# ***City of Albuquerque***

**Re: Wyoming Terrace Mobile Home Park, 900 Zuni Rd. NE, Grading and  
Drainage Plan**

**Engineer's Stamp dated 12-08-03 (L20/D6)**

**DRAINAGE PLAN  
FOR  
WYOMING TERRACE MOBILE HOME PARK**

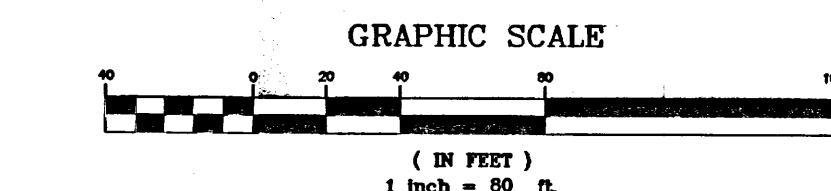
1. Basin C appears to drain to Zuni Rd., yet it is described as draining to Wyoming Blvd.
2. Drainage Basin F drains to Wyoming Blvd. through a concrete rundown, not a wall opening and sidewalk culverts.
3. Basin G appears to drain to Wyoming through a concrete rundown and into 2-20" wide sidewalk culverts, not along the east property line.
